19 July 2013

**Re: Abercrombie Precinct Redevelopment  
Section 75W submission - Architectural Design Statement**

**Table 1 – Proposed modifications**

Drawing title
**PLAN
LEVEL 02**

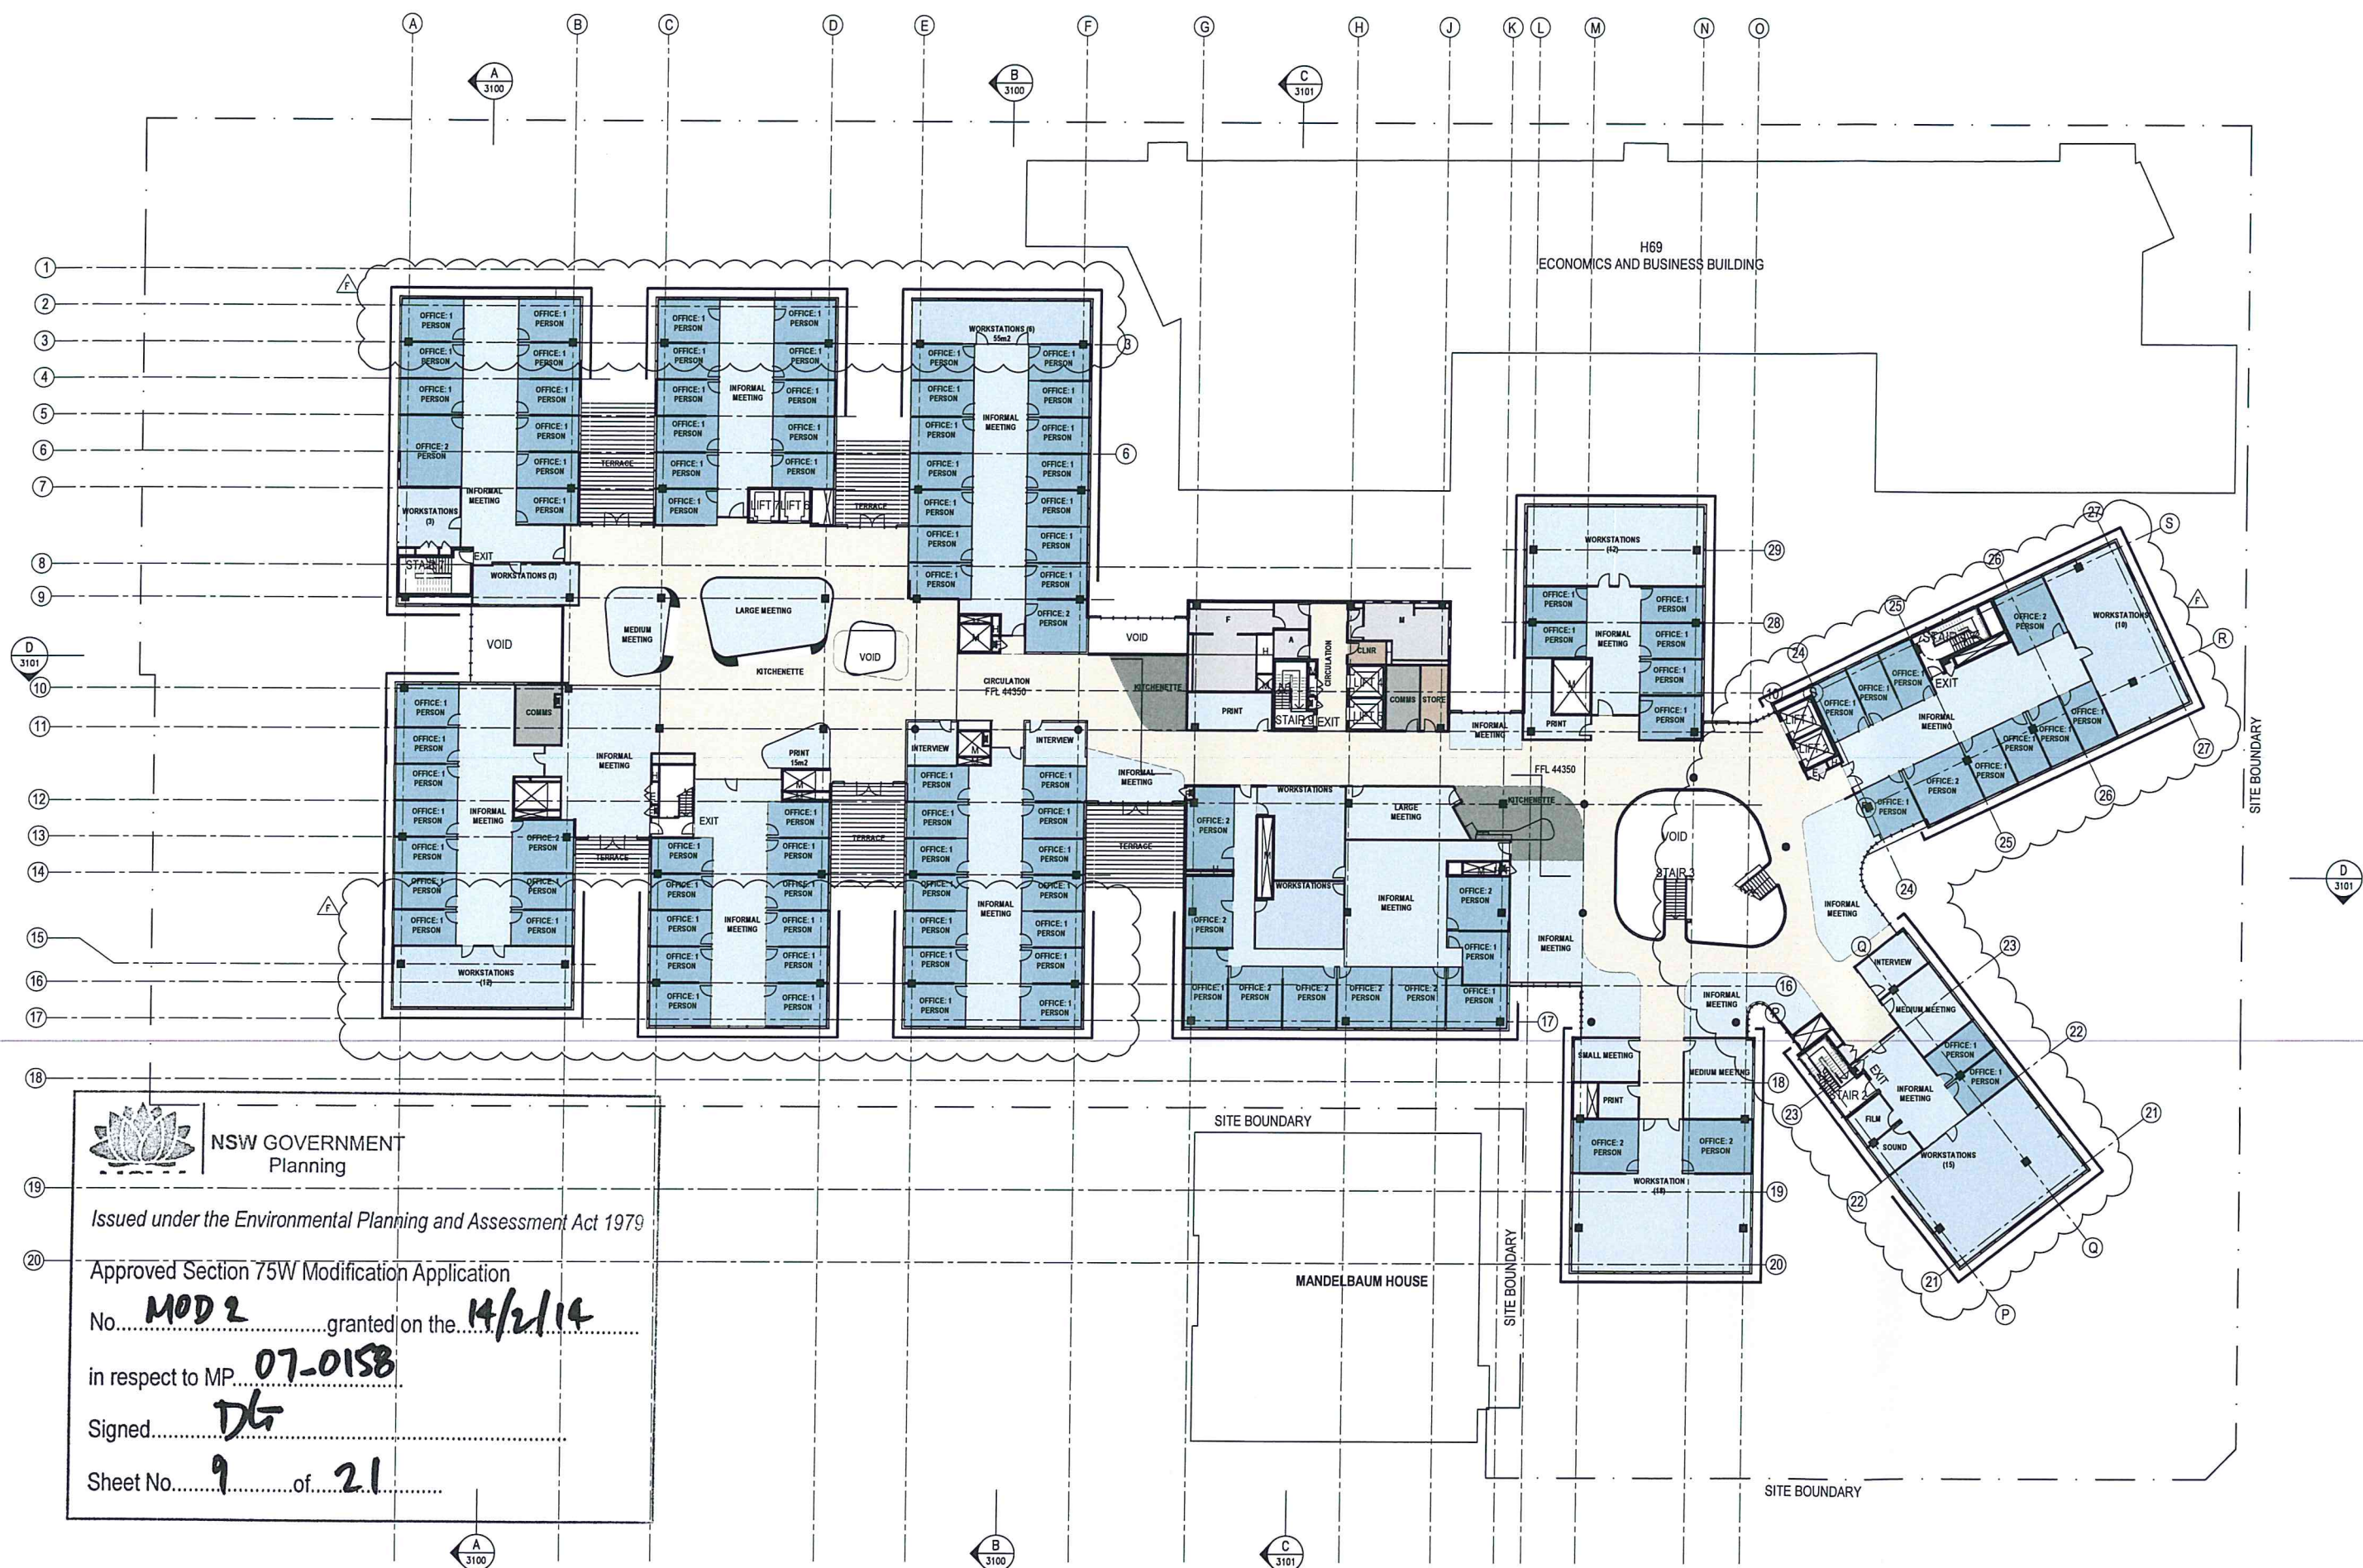
Level	Description of proposed modification	Drawing No.
Level 02	▪ Block B Master's Students Space added.	A2205 Issue E
	▪ Block B Interactive Lounge and Store deleted.

▪ Block C relocated.	
	▪ Block D Terrace deleted.	
	▪ Block D Voids deleted in Area 2.	
	▪ Block E modified to align with south edge of Blocks D & F.	
	▪ Block E Seminar rooms minor layout modification.

▪ Block E Store deleted.	
	▪ Block F Toilets and Lifts relocated to Block J.	
	▪ Block F Small Seminar room added in lieu of Toilets and Lifts.	
	▪ Block G Store deleted and Small seminar room modified to 30 seat capacity.

▪ Stair No. 6 deleted.	
	▪ Locations of Blocks H, J & K modified and aligned with adjacent Blocks.	
	▪ Block L relocated.	
	▪ Stair No. 8 modified.	
	▪ Stair No. 9 relocated.

▪ H69 Economics and Business Building retained as operational during construction phase.	
	▪ Orientation of Block A & Block B modified.	
	▪ Stair No. 3 modified.	
Level 3	▪ Block B minor layout modifications.	A2206 Issue E

Drawing title
**PLAN
LEVEL 04**

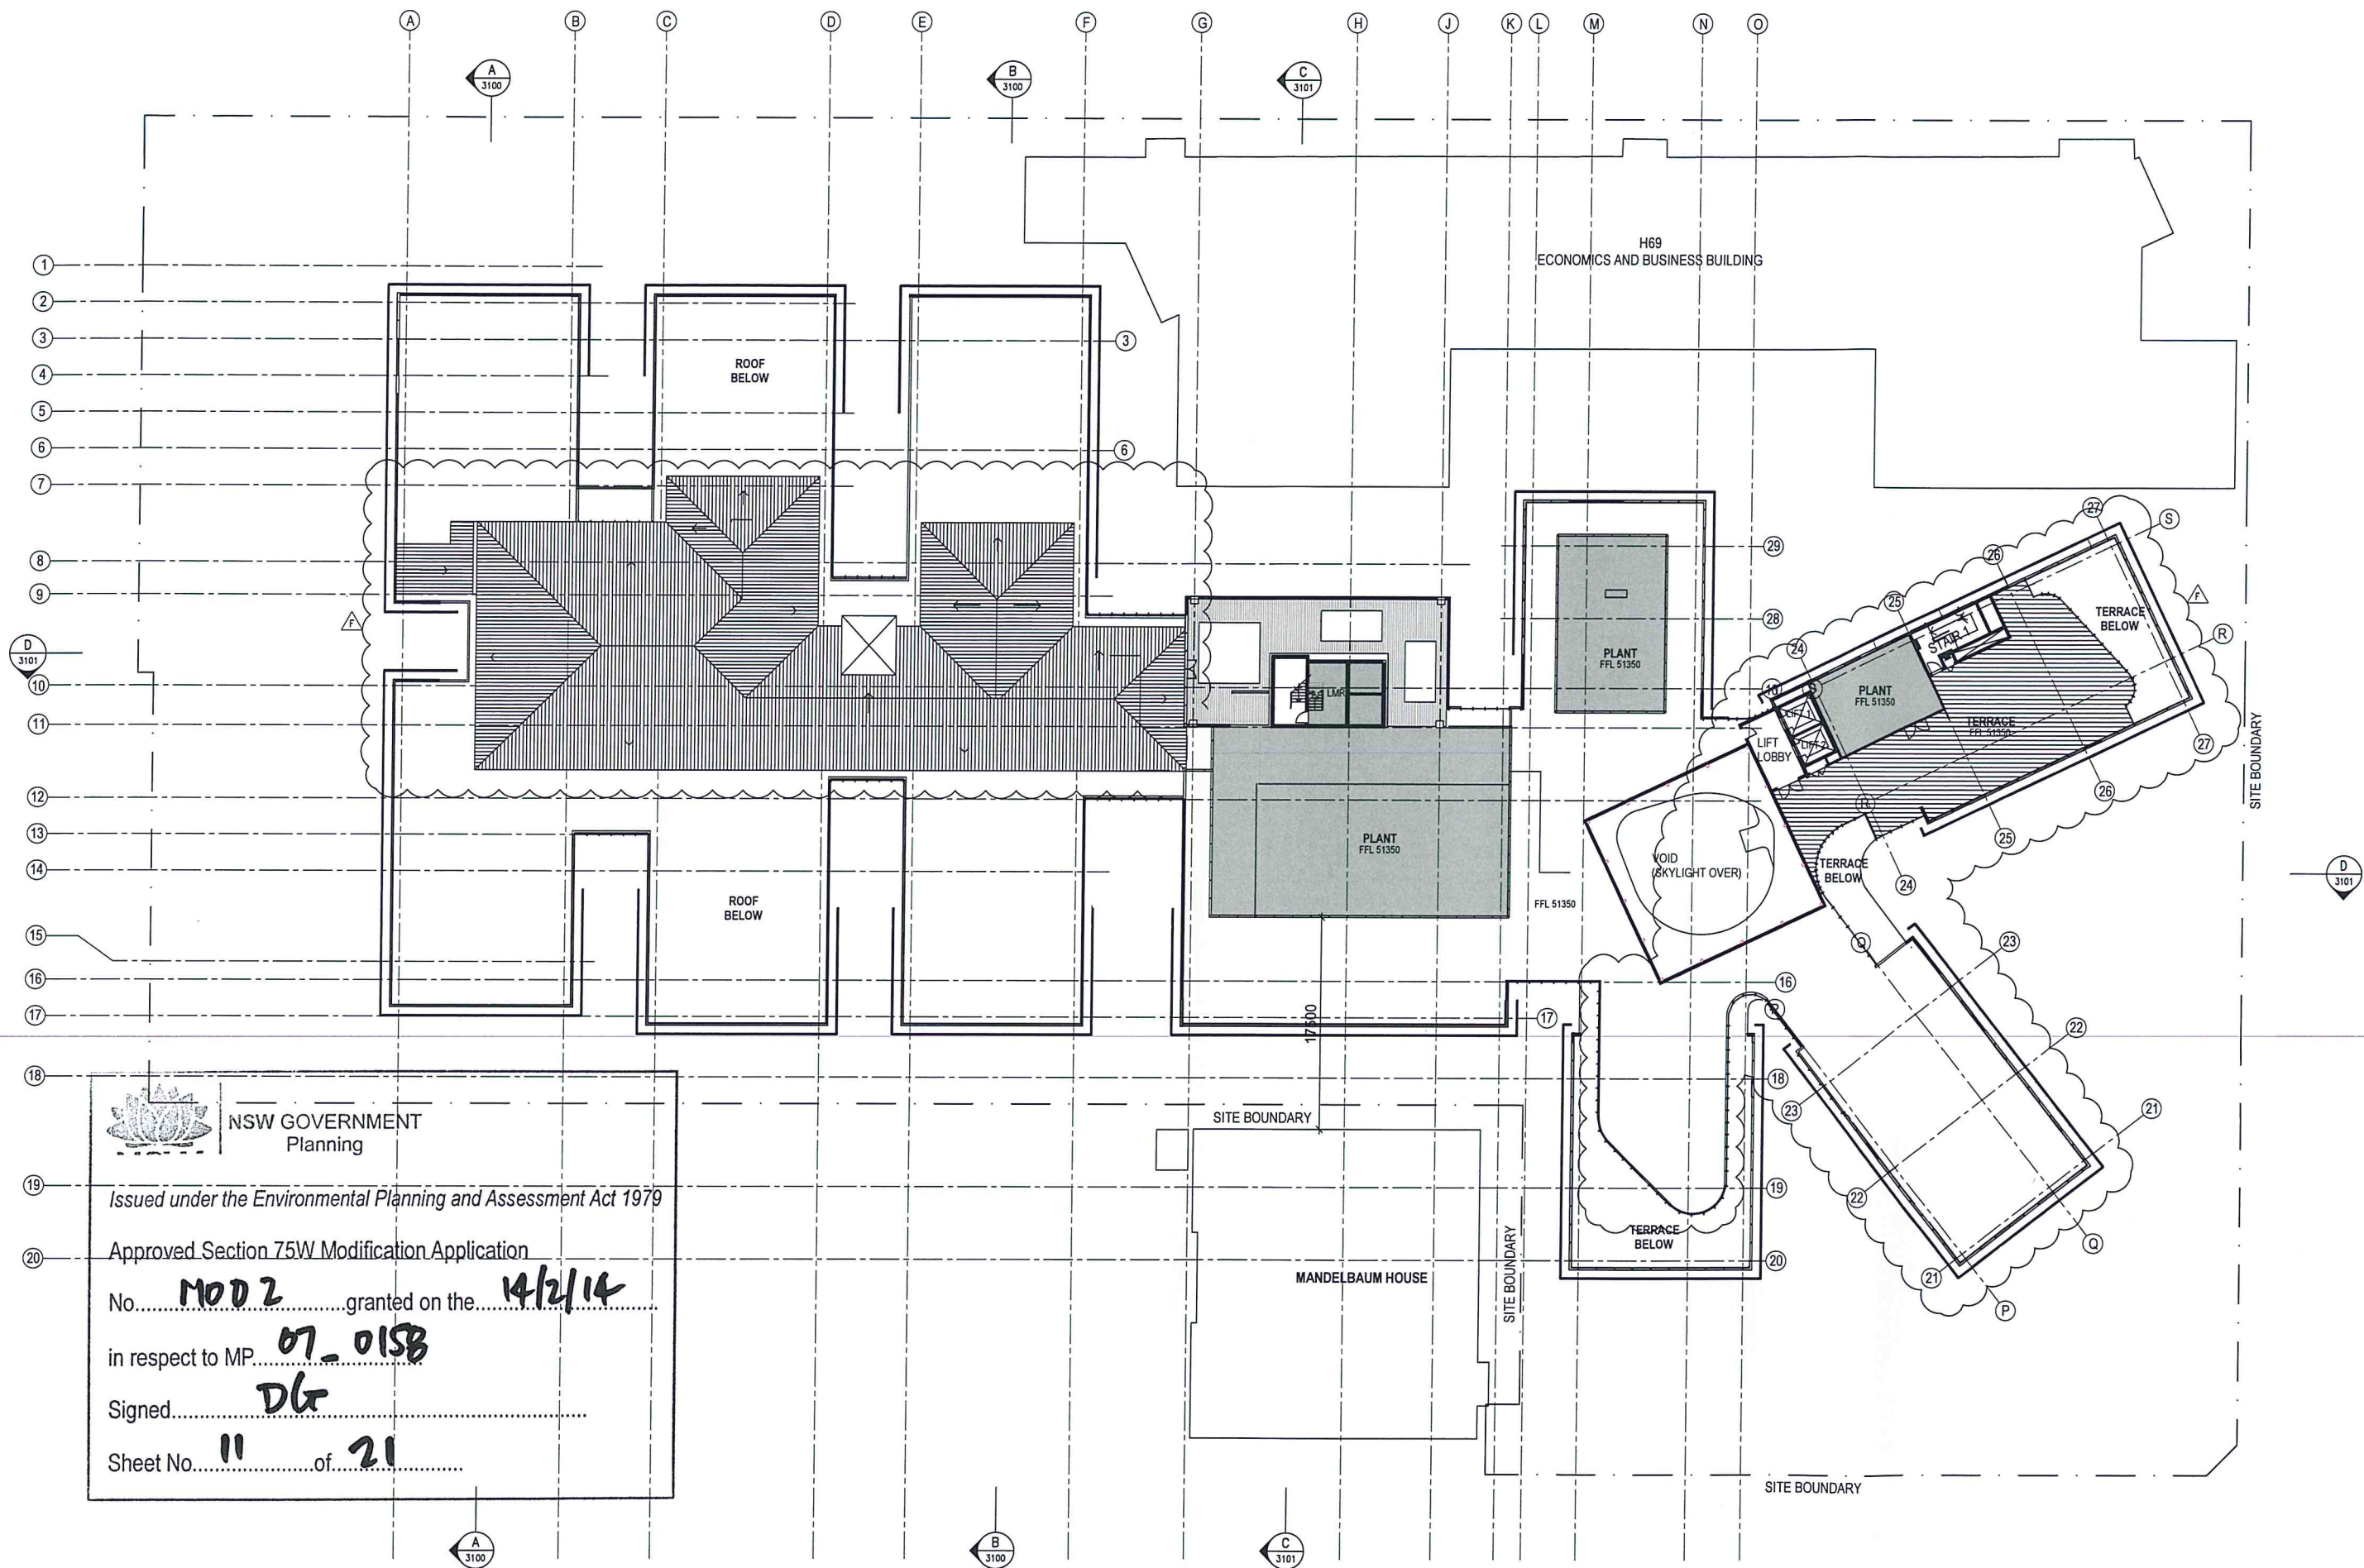
Level	Description of proposed modification	Drawing No.
Level 4	<ul style="list-style-type: none"> <li>Level 5 Block A accommodation relocated to Block B.</li> </ul>	A2207 Issue E
	<ul style="list-style-type: none"> <li>Block C relocated.</li> </ul>	
	<ul style="list-style-type: none"> <li>Block C – Terrace modified, Dining Seating relocated from Block B, Kitchenette and Store added.</li> </ul>	
	<ul style="list-style-type: none"> <li>Block D – Plant added, Toilets and Small Meeting Room relocated to Area 1 adjacent. Large Meeting Rooms and Staff Common deleted.</li> </ul>	
	<ul style="list-style-type: none"> <li>Block E modified to align with south edge of Blocks D &amp; F.</li> </ul>	
	<ul style="list-style-type: none"> <li>Skylight deleted over Area 3.</li> </ul>	
	<ul style="list-style-type: none"> <li>Plants spaces over Blocks E, F, G, H, J &amp; K amalgamated.</li> </ul>	
	<ul style="list-style-type: none"> <li>Locations of Blocks H, J &amp; K modified and aligned with adjacent Blocks.</li> </ul>

<ul style="list-style-type: none"> <li>Block L relocated.</li> </ul>	
	<ul style="list-style-type: none"> <li>Stair No. 9 relocated.</li> </ul>	
	<ul style="list-style-type: none"> <li>H69 Economics and Business Building retained as operational during construction phase.</li> </ul>	
	<ul style="list-style-type: none"> <li>Orientation of Block A &amp; Block B modified.</li> </ul>	
	<ul style="list-style-type: none"> <li>Stair No. 3 and void modified.</li> </ul>	
Level 5	<ul style="list-style-type: none"> <li>Block L relocated.</li> </ul>	A2208 Issue E
	<ul style="list-style-type: none"> <li>H69 Economics and Business Building retained as operational during construction phase.</li> </ul>	
	<ul style="list-style-type: none"> <li>Orientation of Block A &amp; Block B modified.</li> </ul>	
	<ul style="list-style-type: none"> <li>Block A office accommodation deleted, Roof Terrace and Plant added.</li> </ul>
